From: Martyn White <Martyn.White@arun.gov.uk>
Sent: 10 June 2021 16:57
To: Planning.Responses <Planning.Responses@arun.gov.uk>
Cc: Finlay Gardner <Finlay.Gardner@arun.gov.uk>
Subject: AW/183/21/PL

AW/183/21/PL

36 Kingsway Aldwick PO21 4DH

Variation of condition imposed under AW/71/18/HH relating to condition 2-approved plans.

Proposed East Elevation PLANNING ISSUE	
Drawing No. C0019-P214	Date JANUARY 2021
Scale ISSUED 1:100 @ A3	Revision C

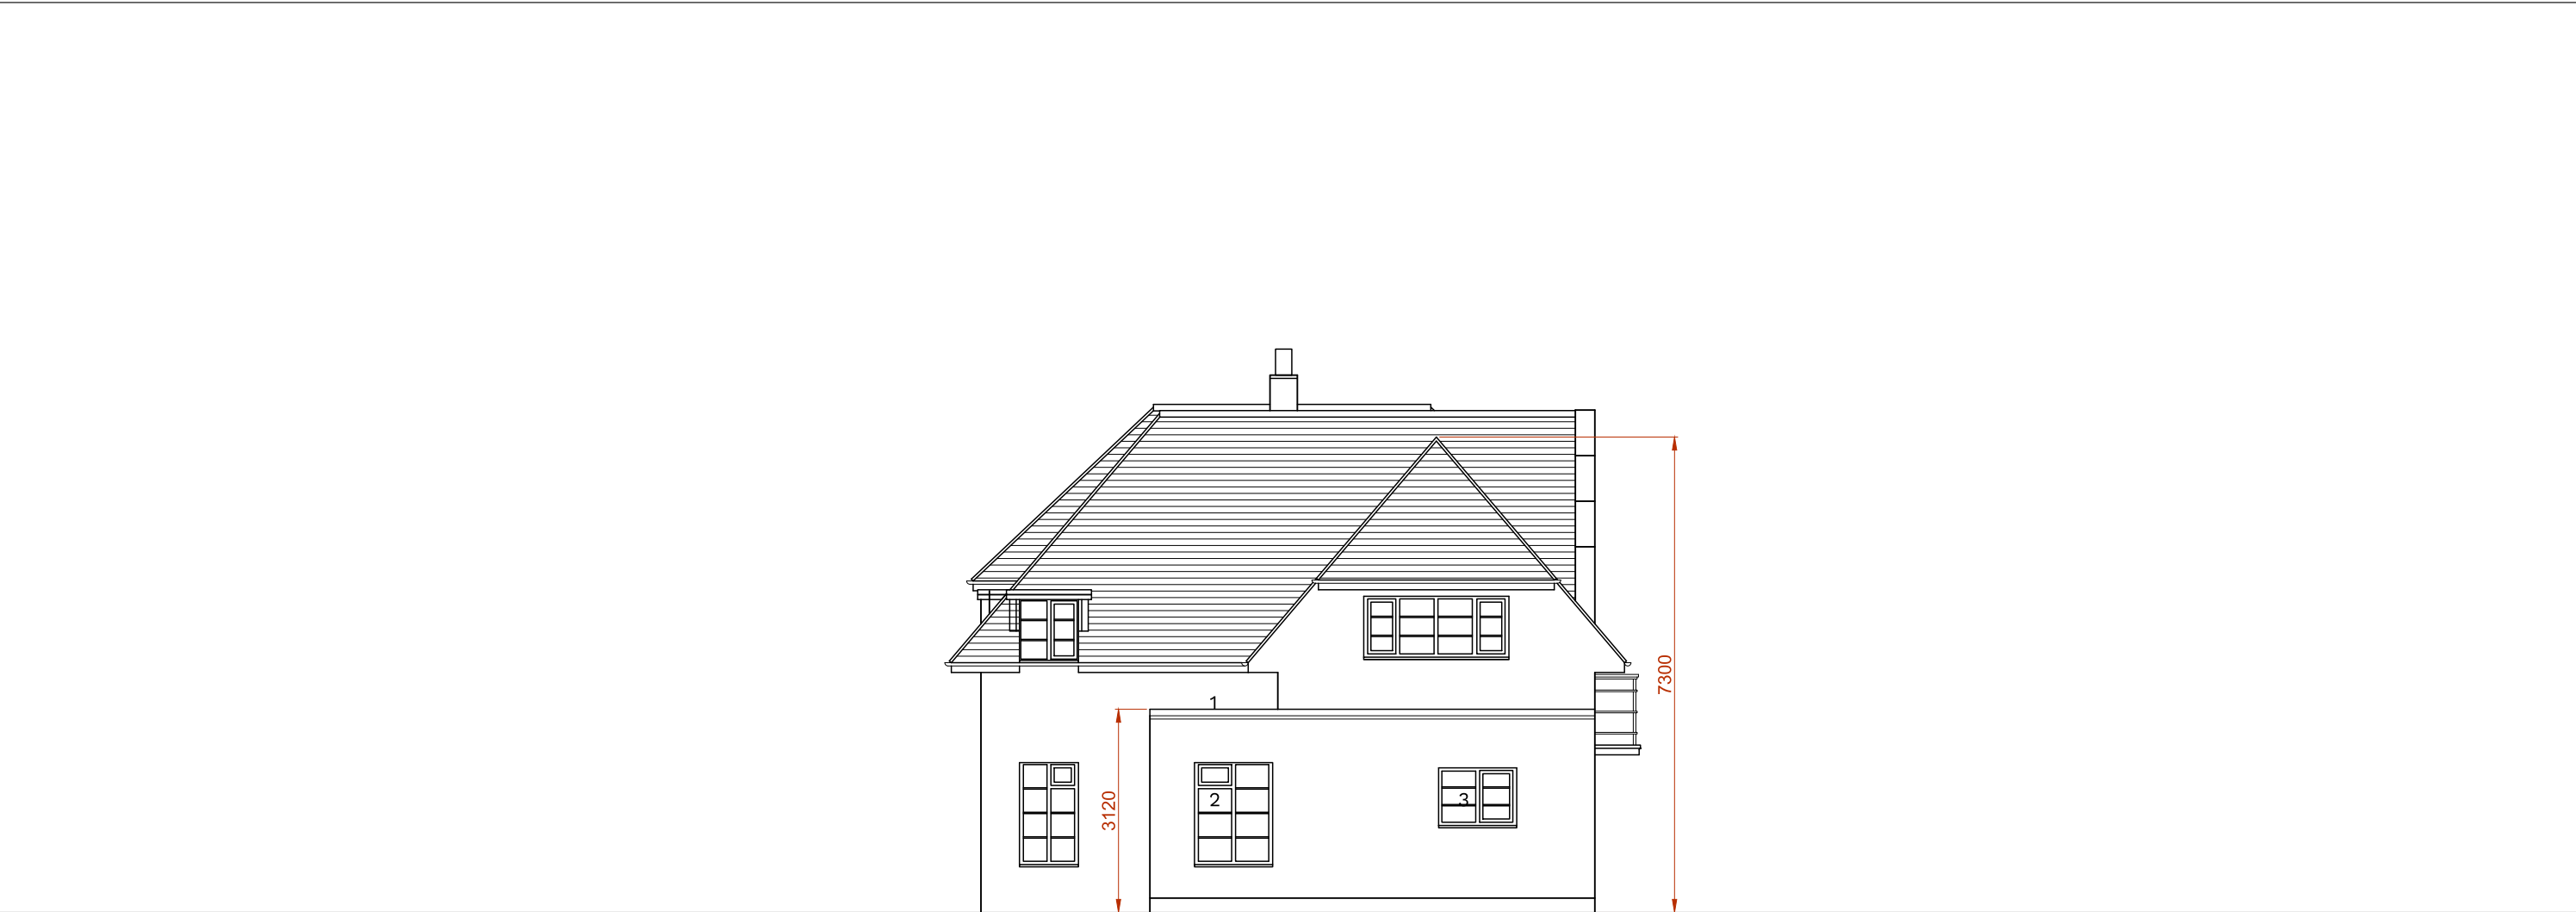
The application requests a variation of condition imposed under application AW/71/18/HH (condition number 2) which identifies the approved plans. It would have helped to be able to understand how the revised plans differed from the previously approved ones. However, I have now taken the time to do this and note that the revision appears to relate to an amendment to the eastern elevation. This amendment relates to the construction of a larger extension which would extend beyond the eastern elevation.

The proposed extension would be fairly small in scale and has been designed to reflect both the existing building and previously approved plans. Whilst the materials appear to match the existing,

it would help to make sure that the windows/doors are appropriate for the attractive building. On balance, I am of the opinion that the proposal will not cause harm.
